AT&T SITE NAME:
SCHREIVER AFB

AT&T SITE NUMBER:
COL-02065

SHEET DESCRIPTION:
**EAST
ELEVATION**

SHEET NUMBER:
C-3

SHEET NUMBER:  
**C-3**

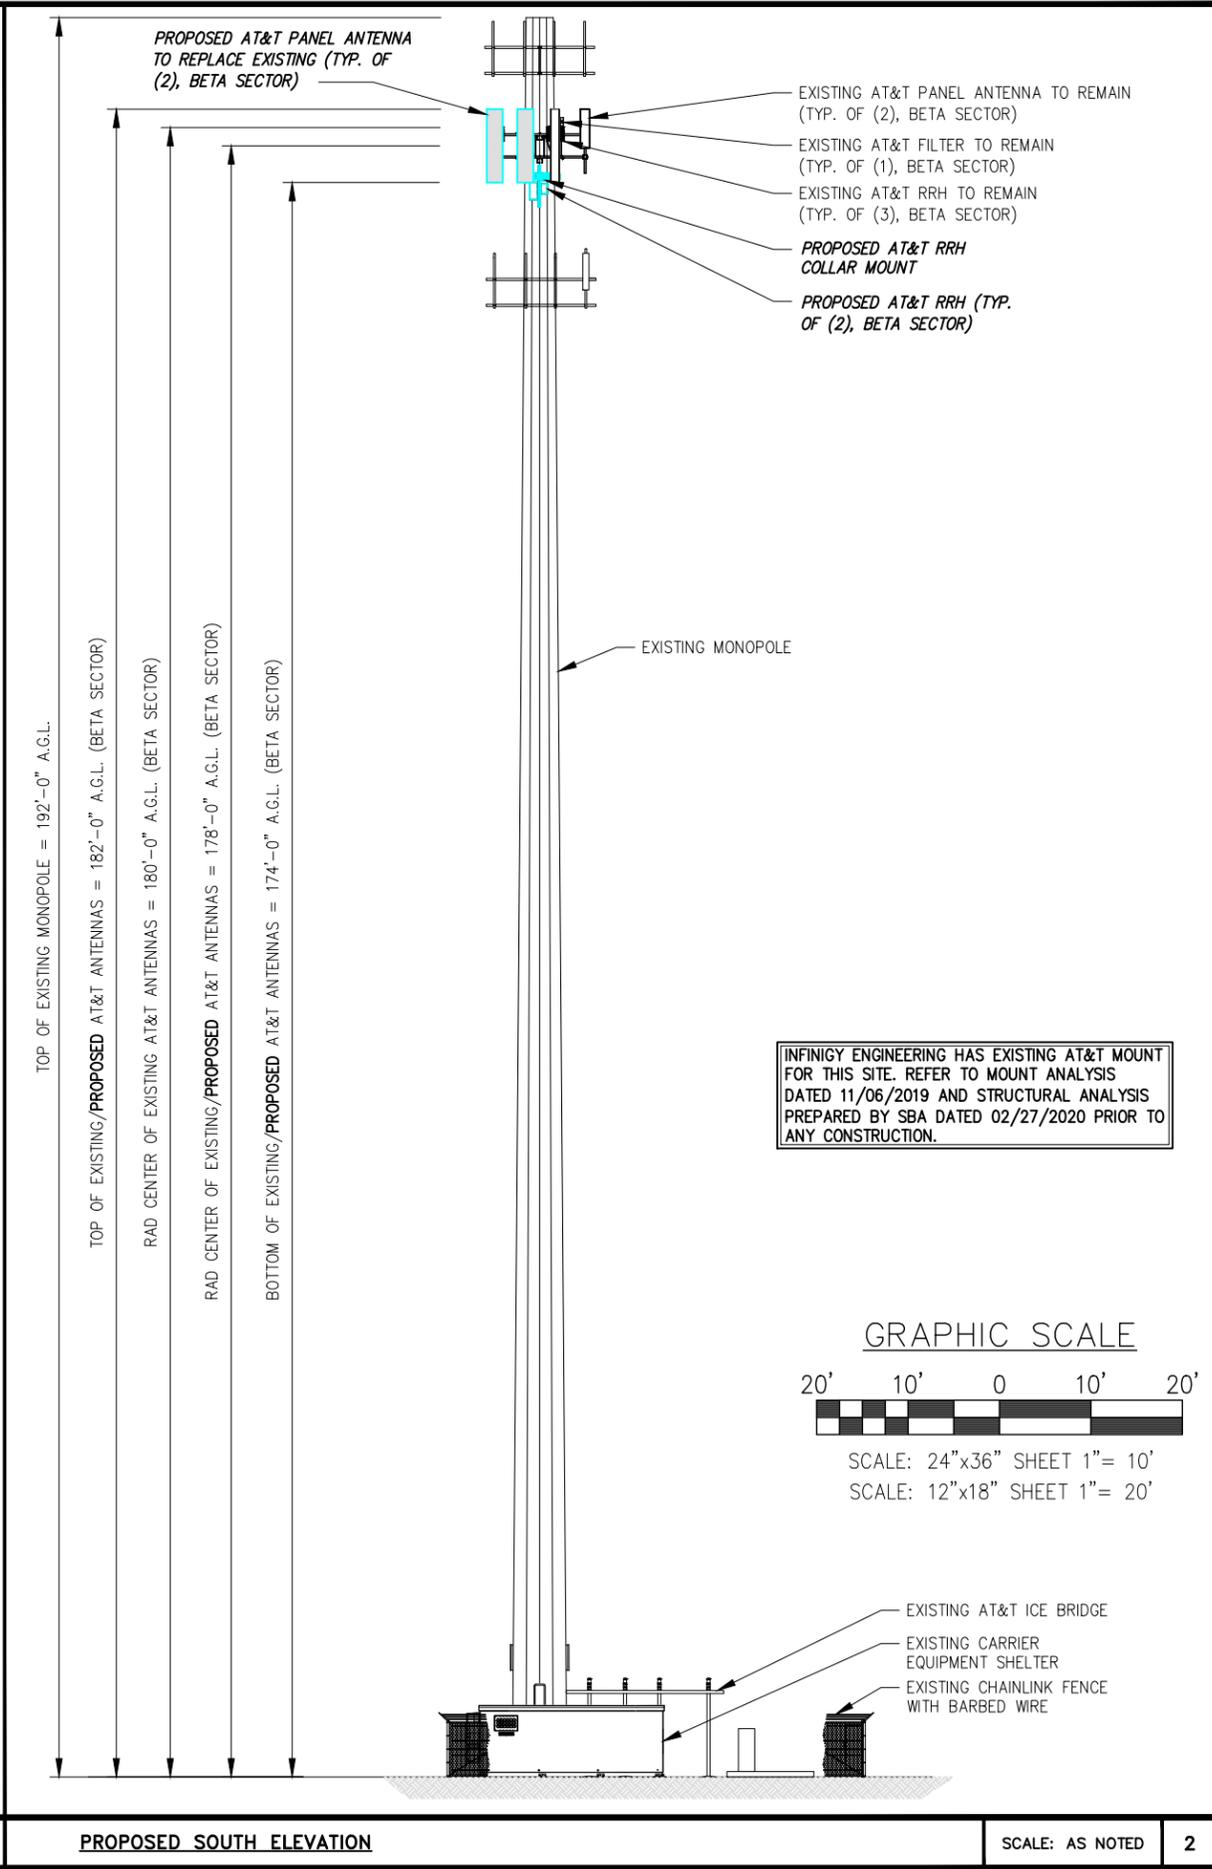
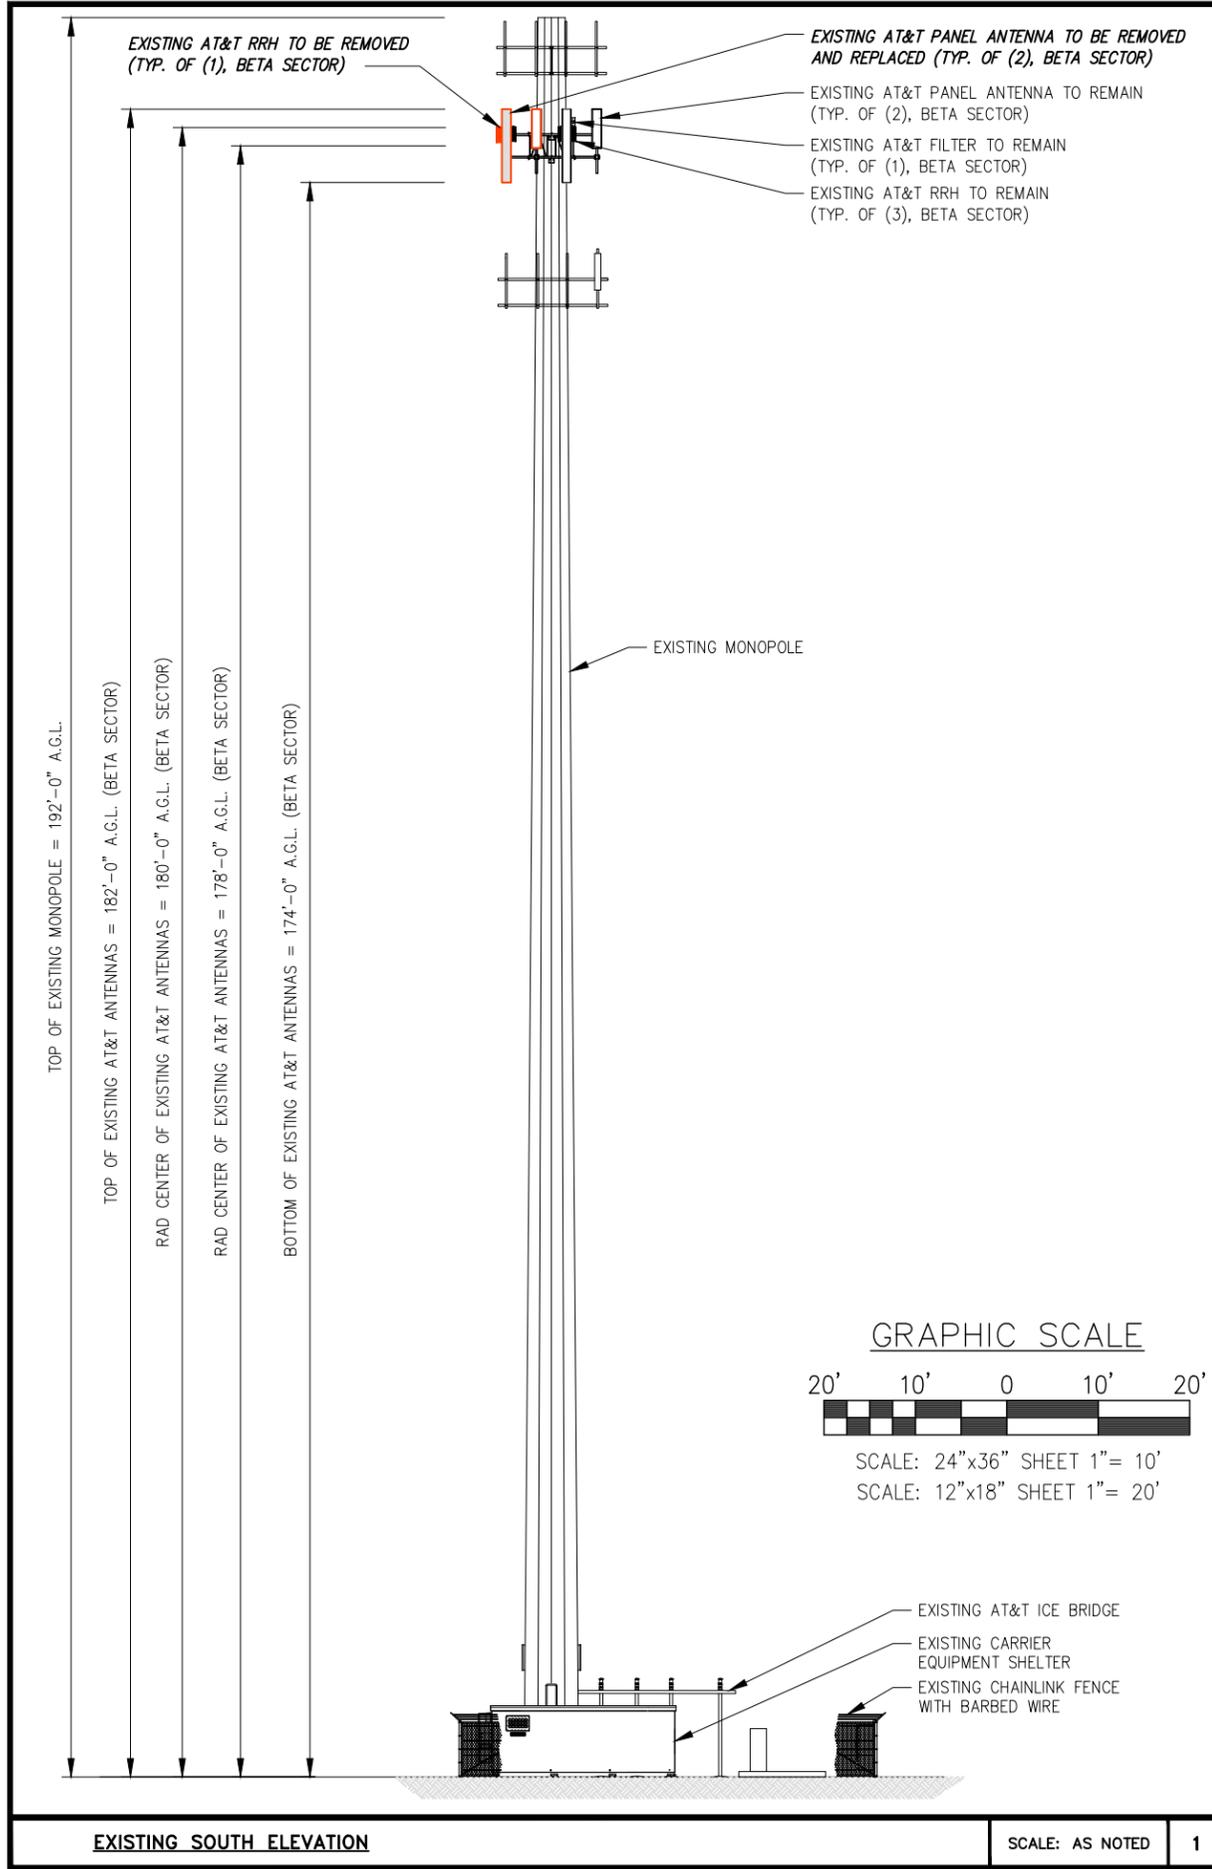
Add PCD File #

Add correct address on each page - 15640 Highway 94 per enumerations comment
